From: Simon Davis
Sent: 15 February 2018 14:33
To: 'da@studio-lets.co.uk'
Subject: AL/136/17/PL Land West of Fontwell Avenue

Application AL/122/17/PL (two semi-detached houses on middle third of the site) was approved at yesterday's Development Control Committee. In addition, you should note that the previous outline for three detached dwellings ref AL/95/13 has expired.

PROPOSED SITE PLAN 1:200

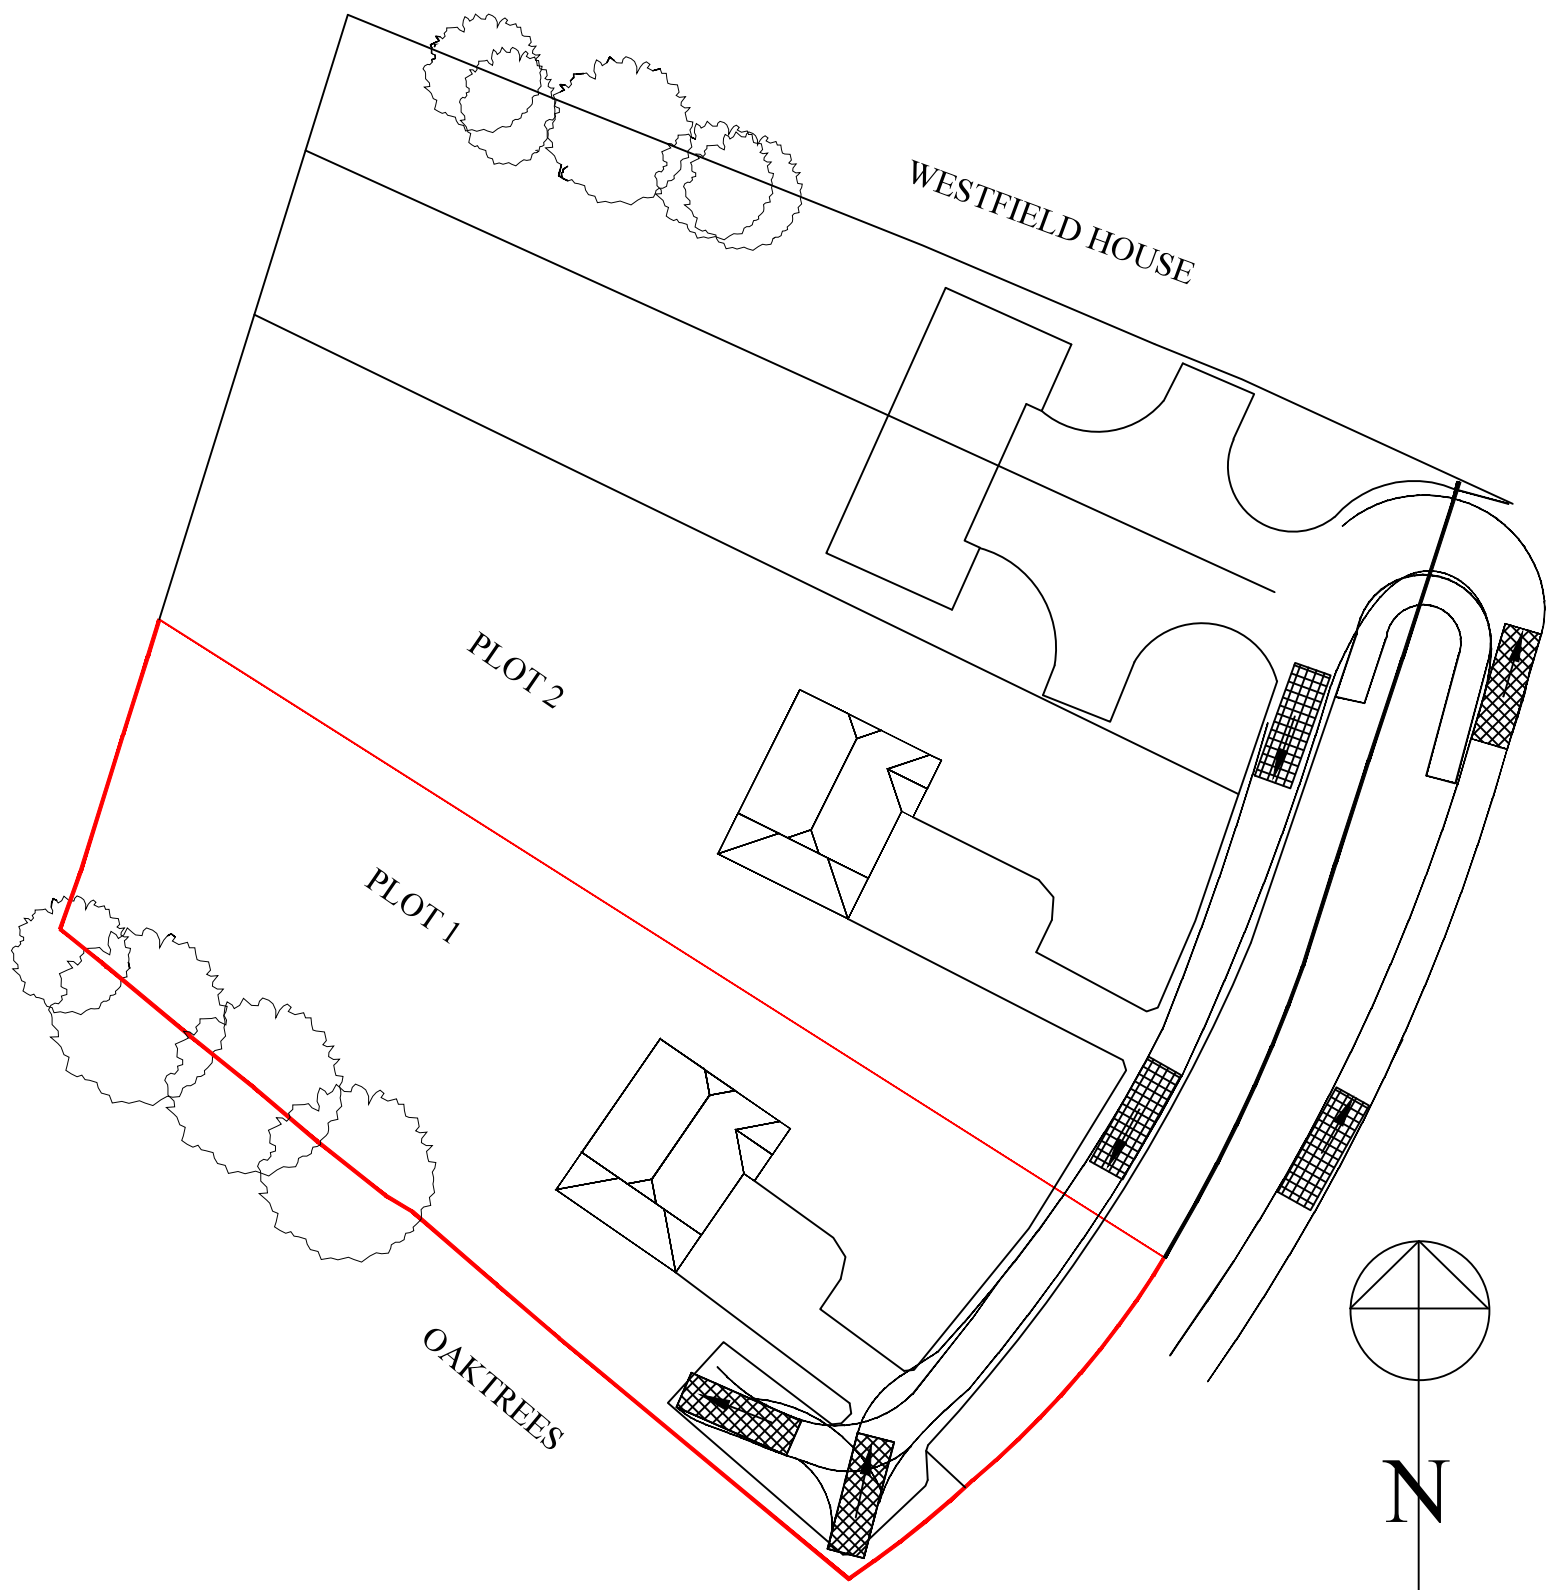
Could you therefore amend your submitted "Proposed Site Plan" to show the middle third of the field occupied by the approved two semi-detached dwellings and not the detached dwelling approved by the previous outline. Please also remove the outline approved detached dwellings from your "Approved Site Plan" as these are no longer approved having expired.
